Re: Greater Dublin Drainage Project consisting of a new wastewater treatment plant, sludge hub centre, orbital sewer, outfall pipeline and regional biosolids storage facility
Townlands of Clonshagh, Dubber and Newtown, County Fingal and Dublin City

Observation in Respect of a Strategic Infrastructure Development Application

Fingal County Council Ref: SID/03/18
An Bord Pleanála Ref: ABP-301908-18

Observation made by Conroy Crowe Kelly Architects on behalf of Gannon Properties.

Drawing file: GDD Planning Drawings / 32102902-2148_P01  Proposed Culvert at Mayne River Crossing - WwTP Access Road (Sheet 1 of 2).pdf

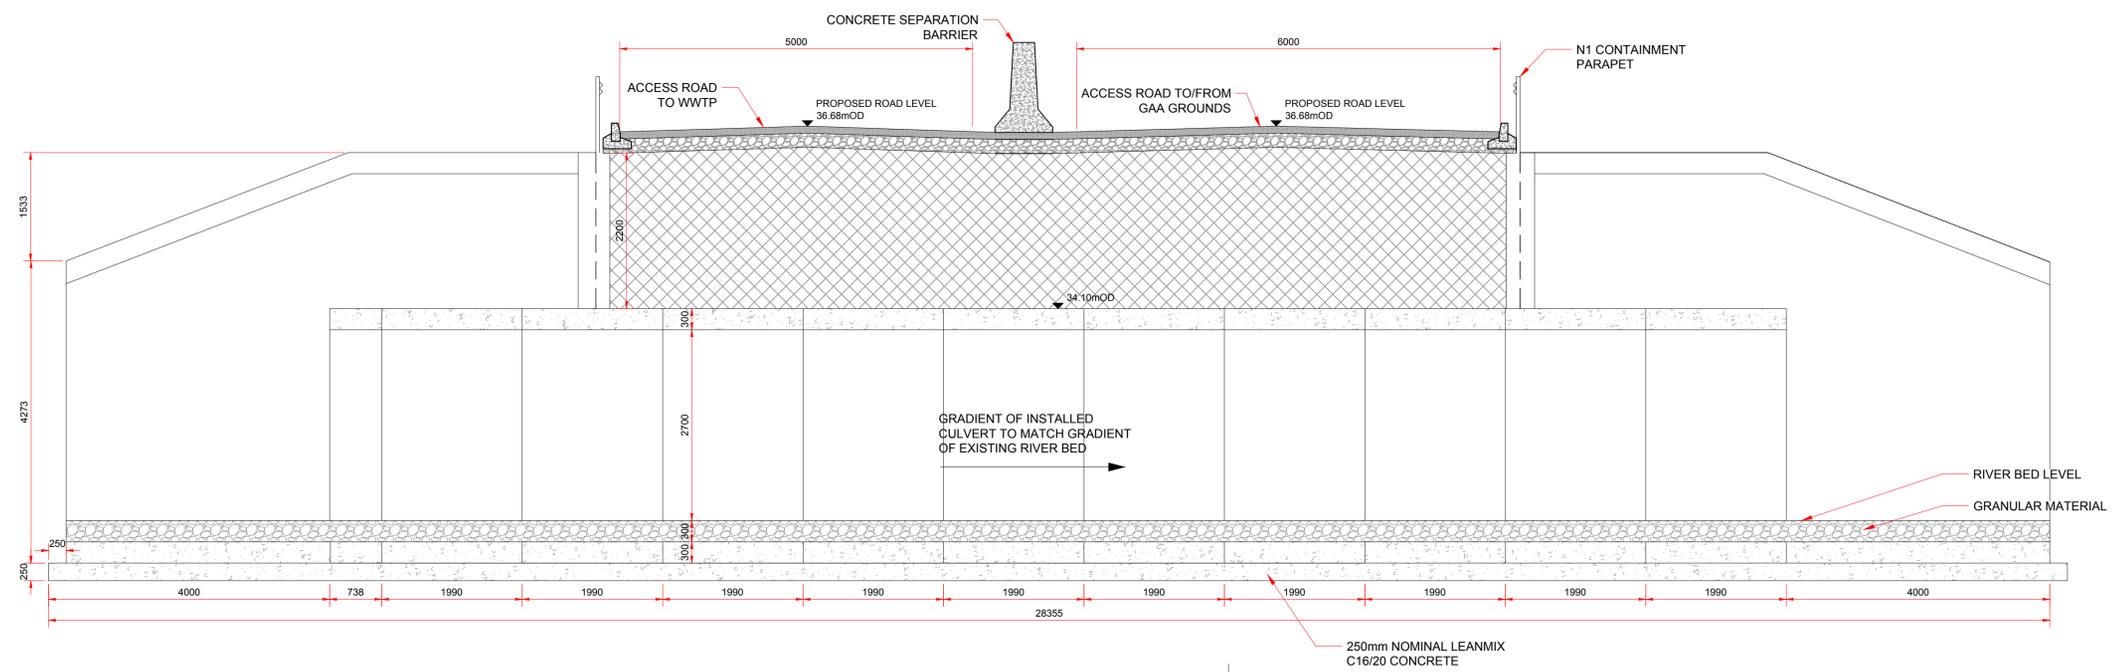
The Applicant proposes a new left-in only access road from the R139 which comprises two carriageways to serve the WwTP and the adjacent GAA lands, separated by a central concrete median. A cross section of this road where it crosses the Mayne River has been submitted with the application, drawing no. 32102902-2148 P01, which indicates that the one-way WwTP access road will be 5m wide and the two-way GAA

access road will be 6m wide. No detailed plan drawings for these roads, the junction with the R139 nor the connection into the GAA lands appear to have been submitted with the SID application.

It is considered that the construction of two separate carriageways serving only the WwTP and the GAA lands is shortsighted, and that future works to upgrade these roads and the culvert to the distributor road standard designed by Atkins will be disruptive, difficult and very costly. No provision for road widening nor for widening the culvert over the Mayne River has been made as part of this SID application by Irish Water.

Observation: *That the access road from the R139 to the WwTP and the Mayne River culvert is designed and constructed to the distributor road standard proposed by the Atkins Orange Route and in accordance with the objectives of the Fingal County Development Plan.*

Looking at the road in section, Jacobs drawing 32102902-2048-P01, a carriageway reservation of 5m is provided to access to the WWTP with a parallel 6m carriageway reservation to access the GAA lands also provided with a culvert to negotiate the Mayne River.

2. By not providing for a fully designed distributor road at this stage, subsequent upgrade of the road will present further difficulties in the construction of the Mayne River Culvert, by having to widen it, and reconstruct wing walls, etc. The reservation of 18.5m for the future distributor is about 8m short of the width being provided over the River Mayne in the subject application. The culvert design should be amended to provide for a future 18.5m wide carriageway and should be designed for full road traffic loading.
